OAKDALE WEST ESTATE (OWE)
NOISE & VIBRATION ASSESSEMENT
INDEPENDENT ADEQUACY REVIEW & GAP ANALYSIS

REPORT NO. 14614
VERSION A

MARCH 2017

Wilkinson Murray Pty Limited (WM) has been commissioned by Goodman in a peer review role capacity to undertake a technical review of the OWE NVIA, provide comment on its adequacy and where necessary identify any errors or omissions.

Figure 3 Receiver Areas and Modelled Buildings

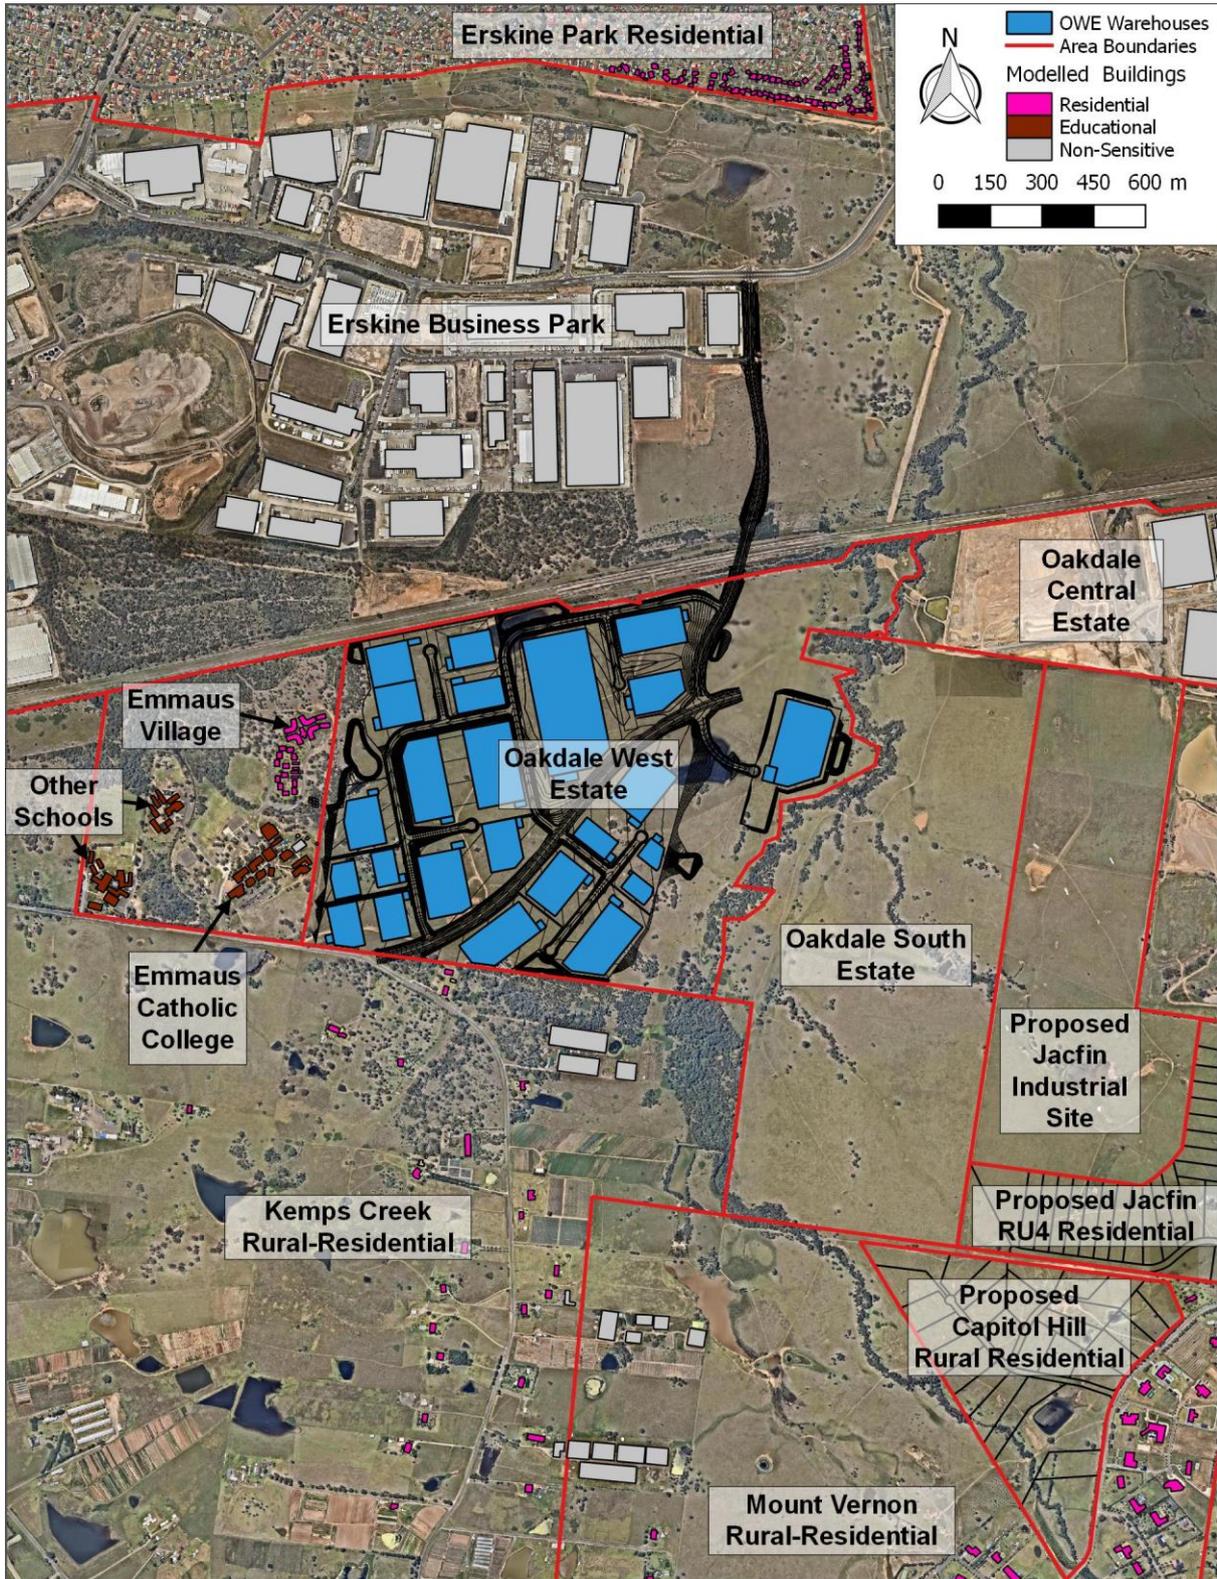
It is not clear at what location(s) the existing and future contributions have been calculated, or exactly how the noise levels from these surrounding sites were determined. It is assumed that a "worst case" contribution has been conservatively adopted.
